**MECKLENBURG COUNTY**  
**Land Use & Environmental Services Agency**

**MEMORANDUM**

Subject: Rezoning Petition Comments

**2023-092: Great American Storage LLC**

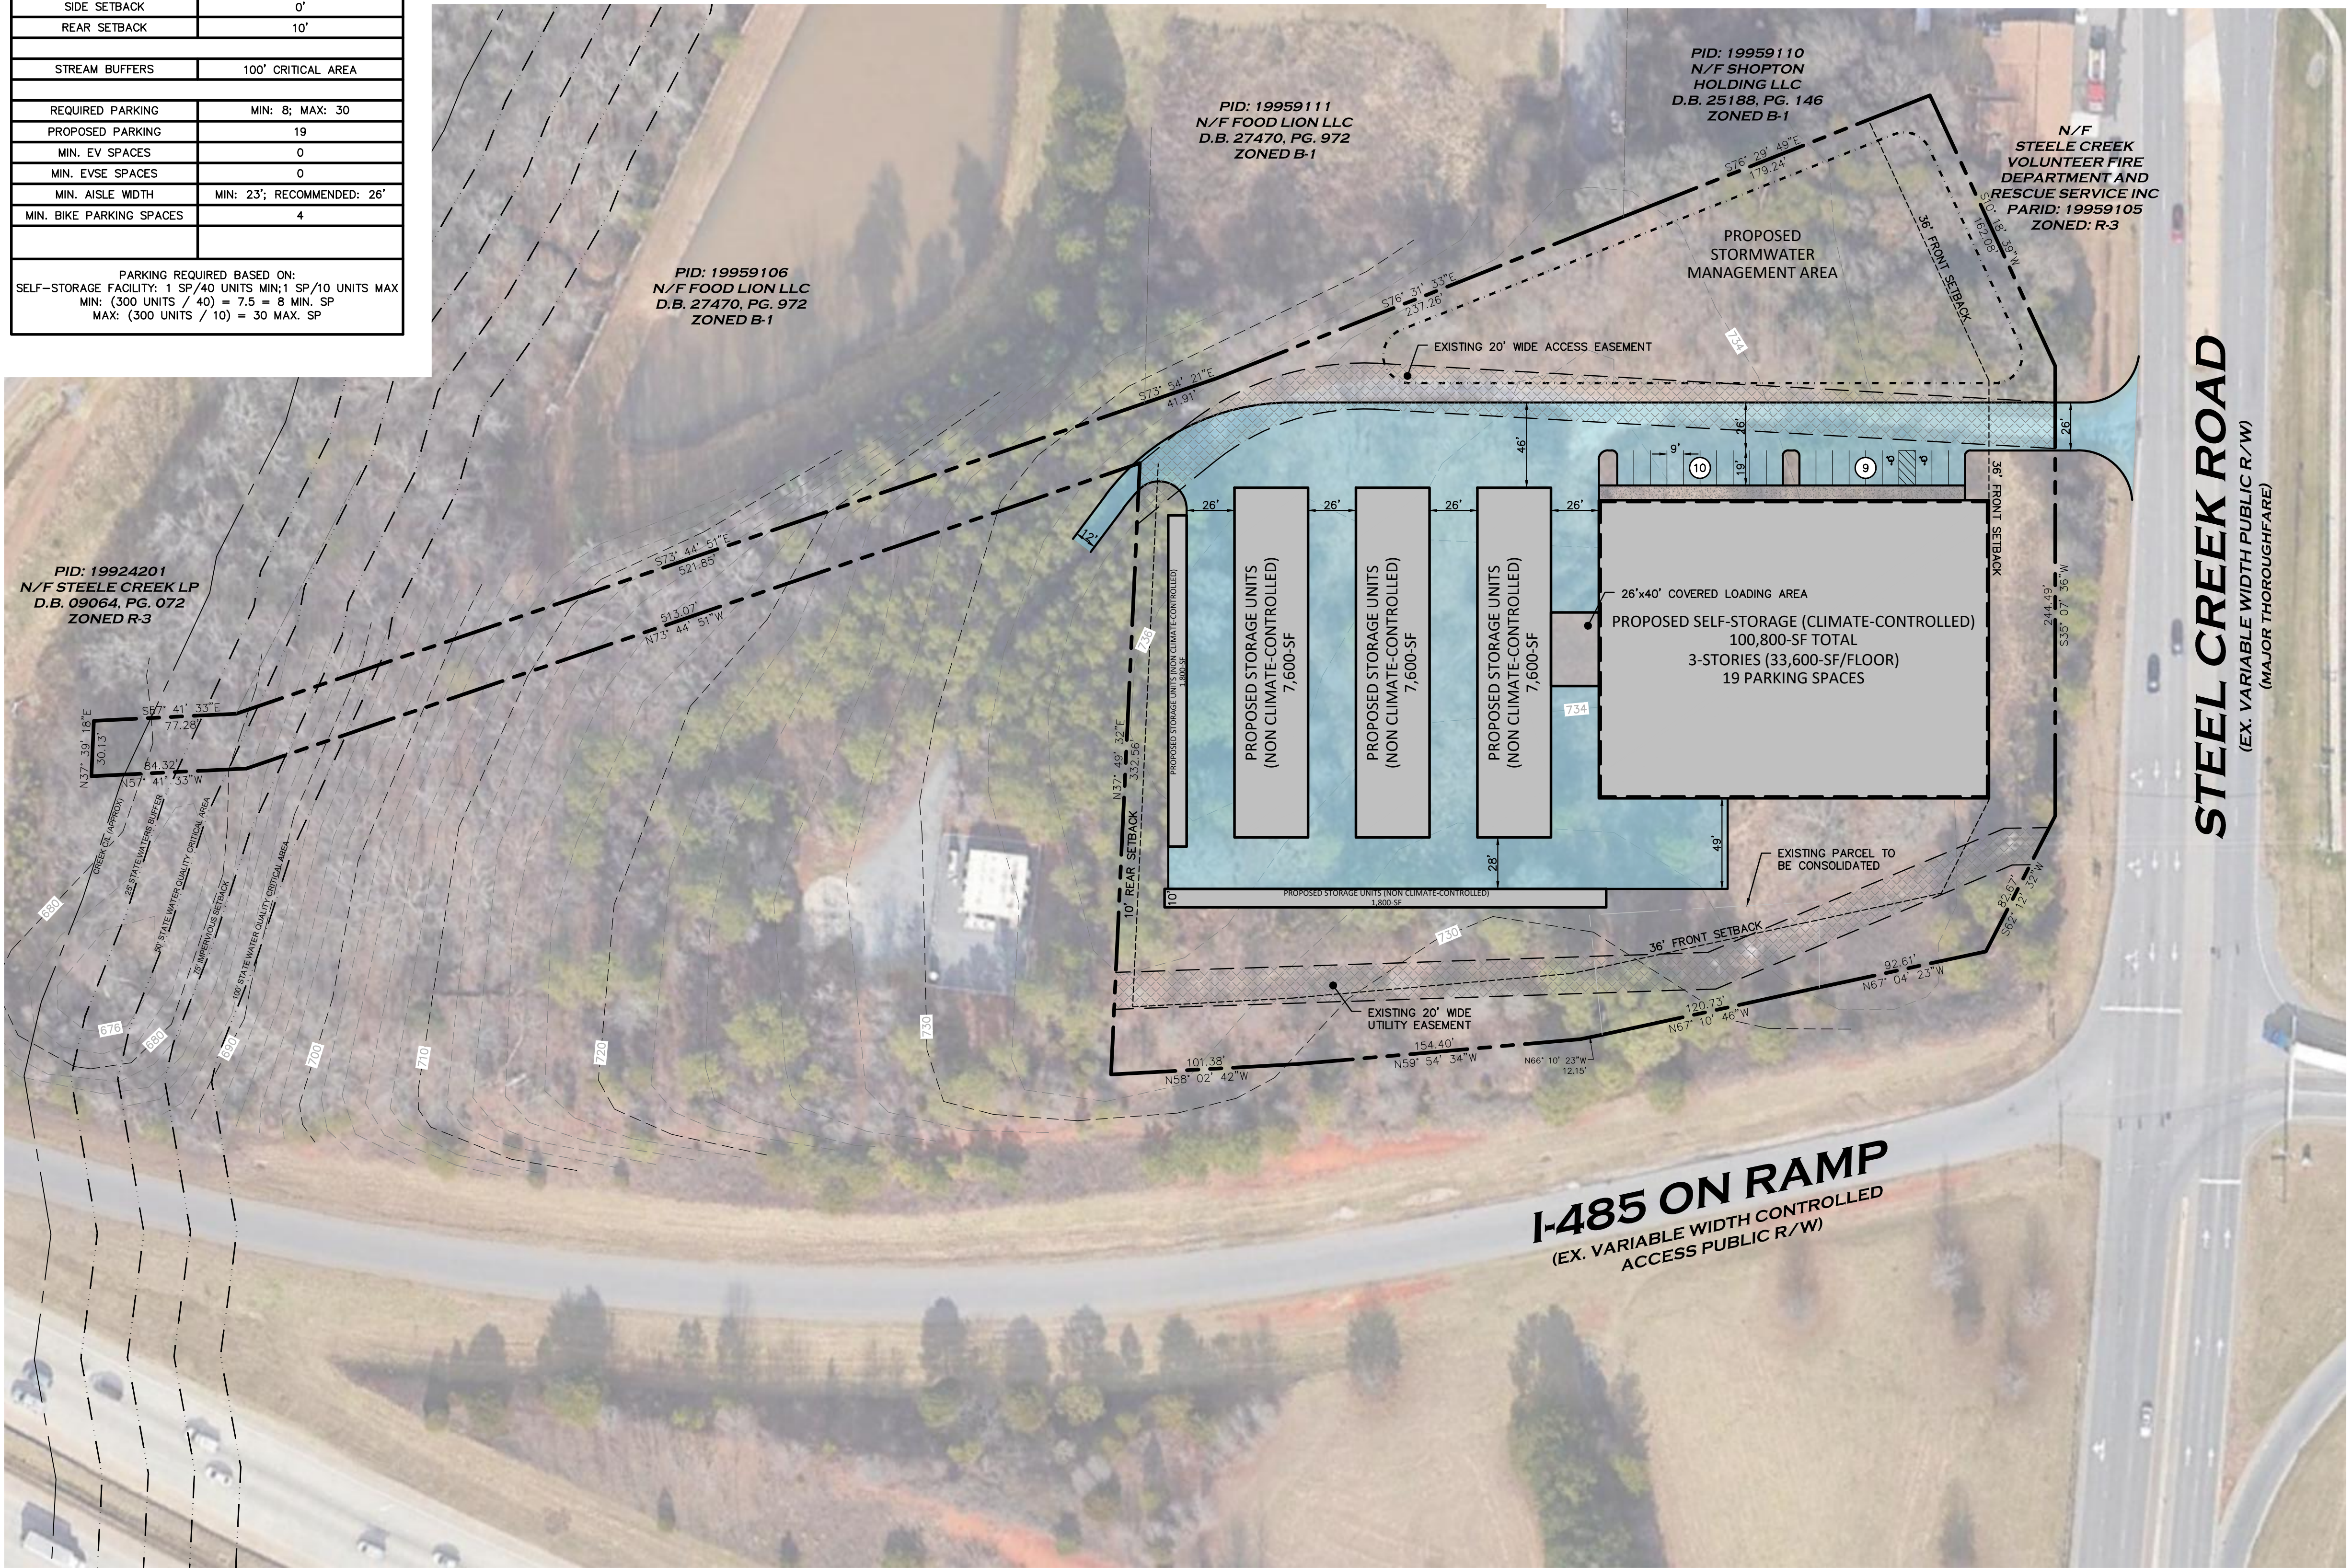
Groundwater & Wastewater Services (GWS) records indicate that a water supply well has been registered and located within the bounds of parcel 199-591-04. Water supply wells should be protected during site development by flagging and fencing or be permanently abandoned in accordance with the Mecklenburg County Groundwater Well Regulations prior to site development commencing.
